Fuel Church Transportation Memorandum (LSC #204460) September 16, 2020

RE: Fuel Church
 El Paso County, CO
 Transportation Memorandum
 LSC #204460

LSC Transportation Consultants, Inc. has prepared this transportation memorandum for the proposed Fuel Church development in El Paso County, Colorado west of the Town of Monument. Located at 16965 Lindbergh Road and referenced by El Paso County parcel ID (7121001009), the site is southeast of the intersection of Schilling Avenue/Lindbergh Road. This report presents the estimated vehicle-trip generation and sight-distance analysis for the proposed access for this currently-planned development.

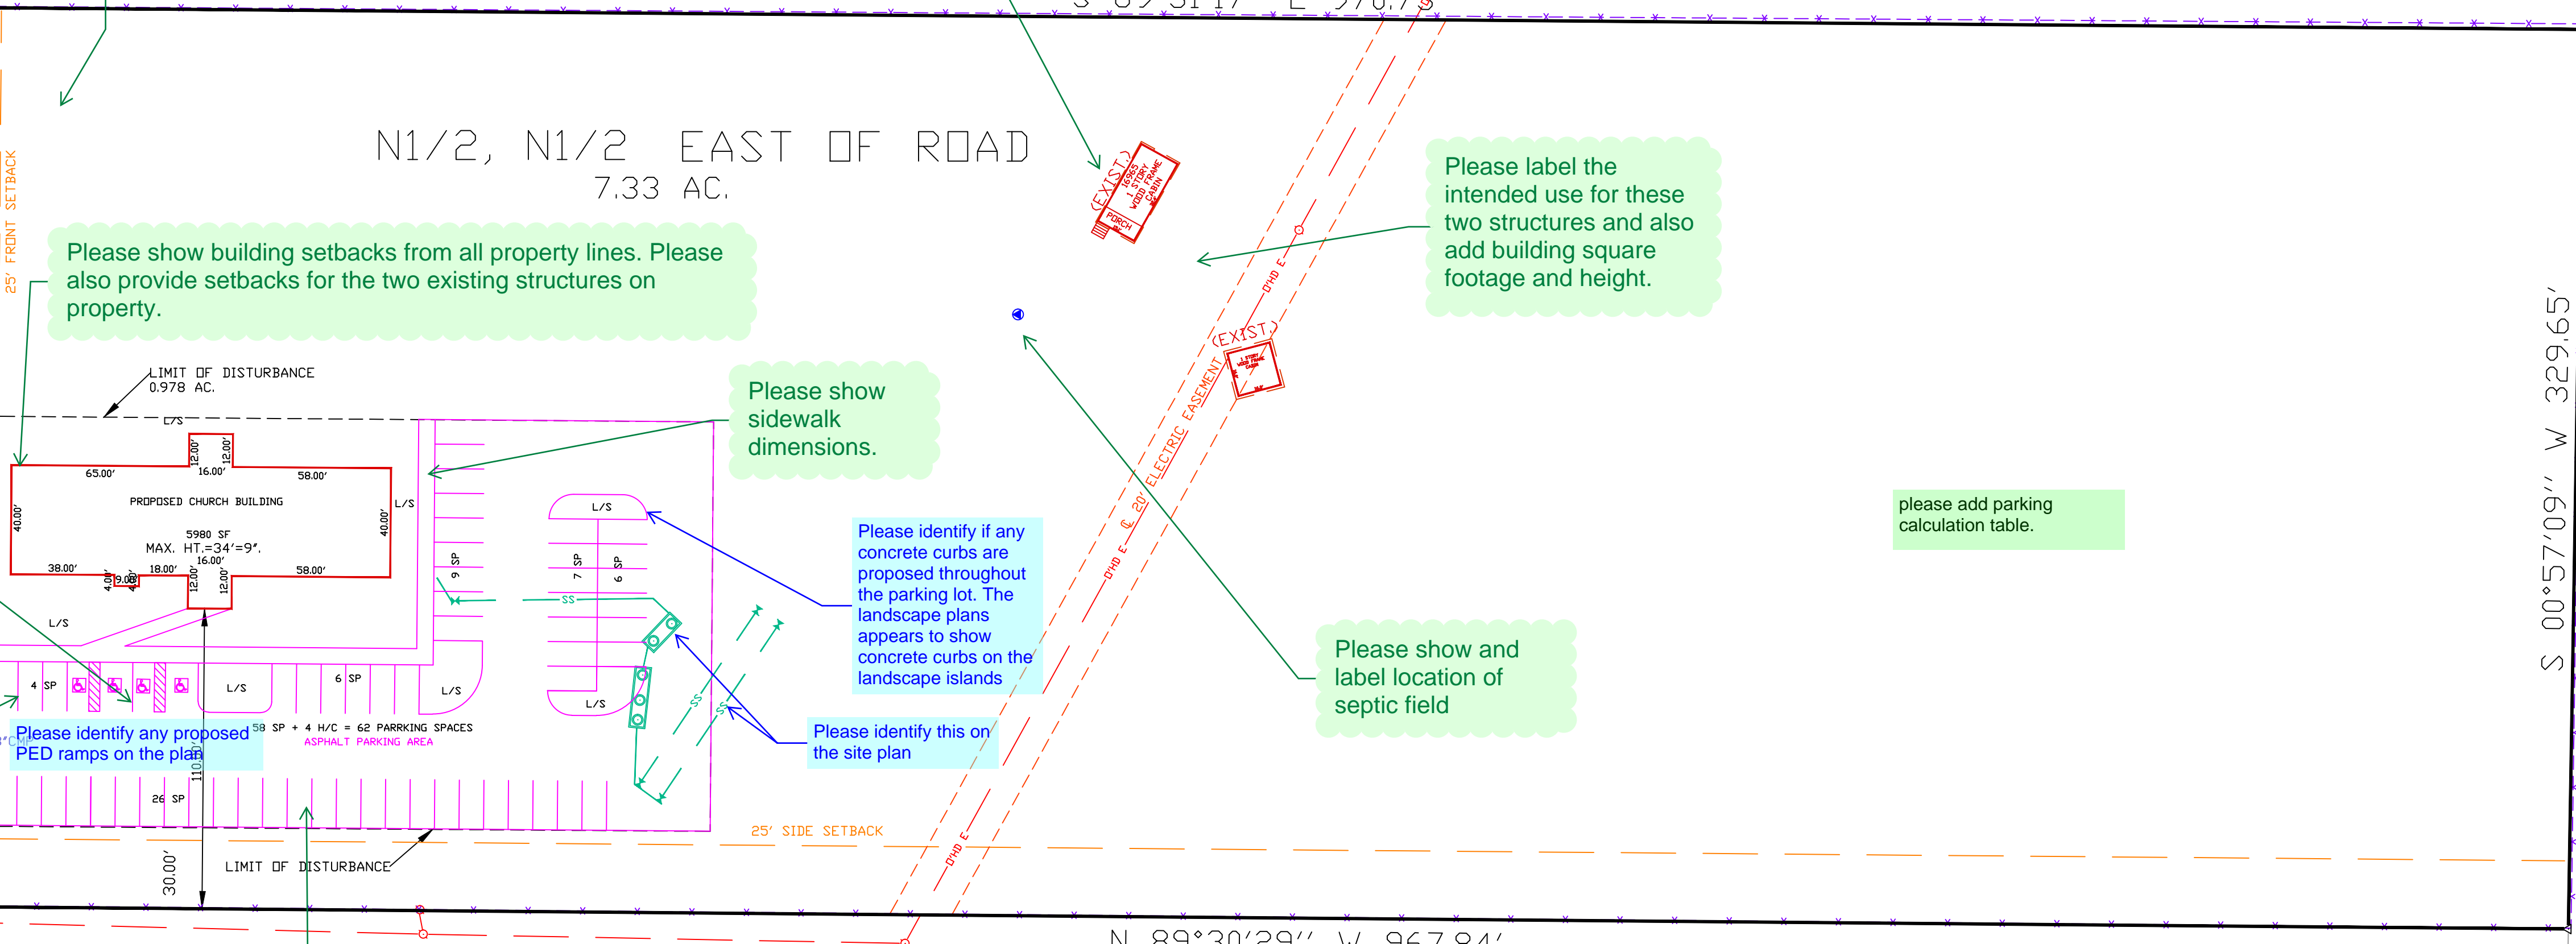
There is an existing access below the proposed parking area. Please provide a discussion on access spacing and location.

Refer to ECM 2.4. A deviation request for consideration by the ECM administrator may be required if the intent is to keep both access points
